**Consultation Response from KC,  
Highways Development Management****2024/90681 adj, 1, Newsome Avenue, Newsome, Huddersfield, HD4 6JW****Outline planning application for erection of detached dwelling****Date Responded: 27-3-2024.****Responding Officer: Mark Berry.****Responding Ref: 6-8SW-11.**

This is an outline planning application with all matters reserved for the erection of a detached dwelling at land adjacent, 1, Newsome Avenue, Newsome, Huddersfield.

Date: FEB 24	Scale @ A3: 1:1250 / 200	Drawn by: AB
Project No: 252	Drawing No: (0-) 01	Revision: A

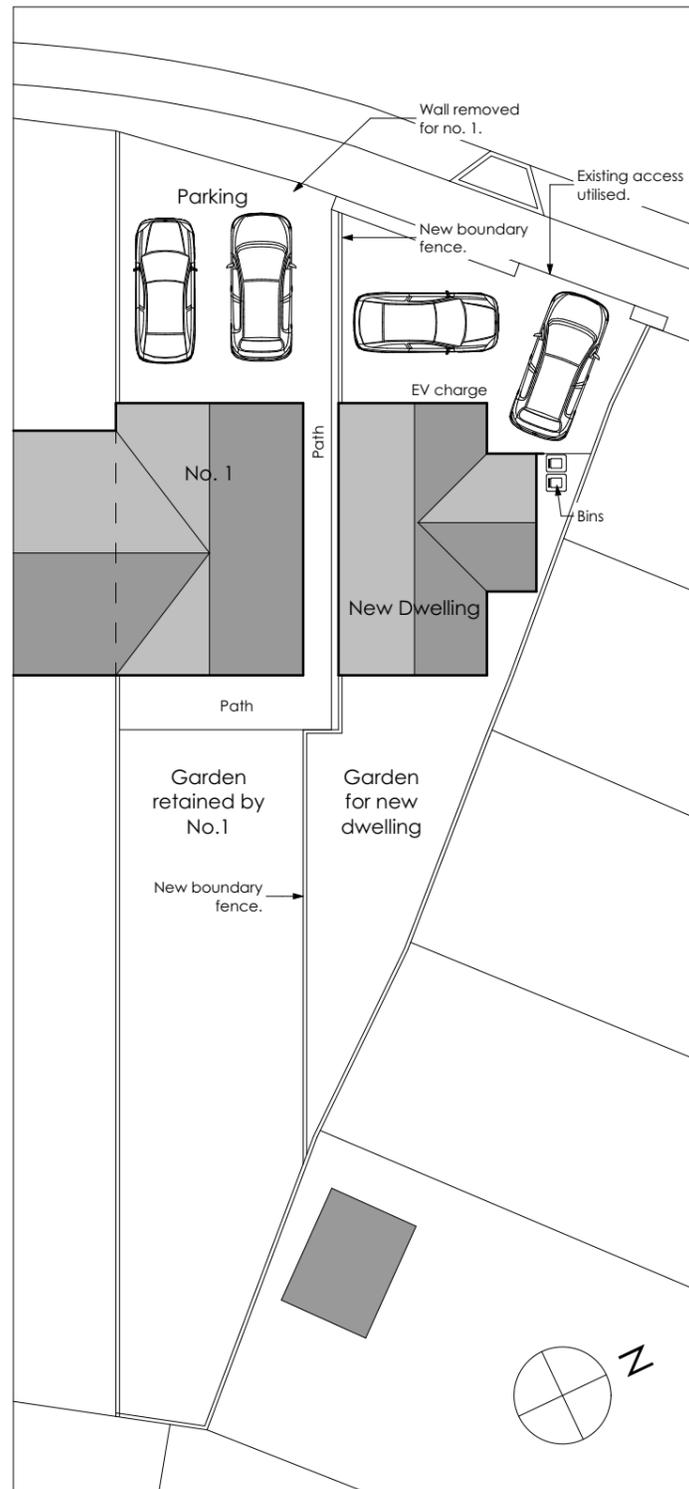
The existing vehicular access from Newsome Avenue will be retained. An indicative area for parking 2 cars has been shown. Two parking spaces are also shown for the existing dwelling within the existing front garden.

Given that sufficient off-street parking is shown to both the proposed and existing dwelling Highways Development Management have no objection to these proposals.

Prior to the development being brought into use, the approved vehicle parking areas shall be surfaced and drained in accordance with the Communities and Local Government; and Environment Agencies 'Guidance on the permeable surfacing of front gardens (**parking areas**)' published 13<sup>th</sup> May 2009 (ISBN 9781409804864) as amended or superseded; and thereafter retained throughout the lifetime of the development.
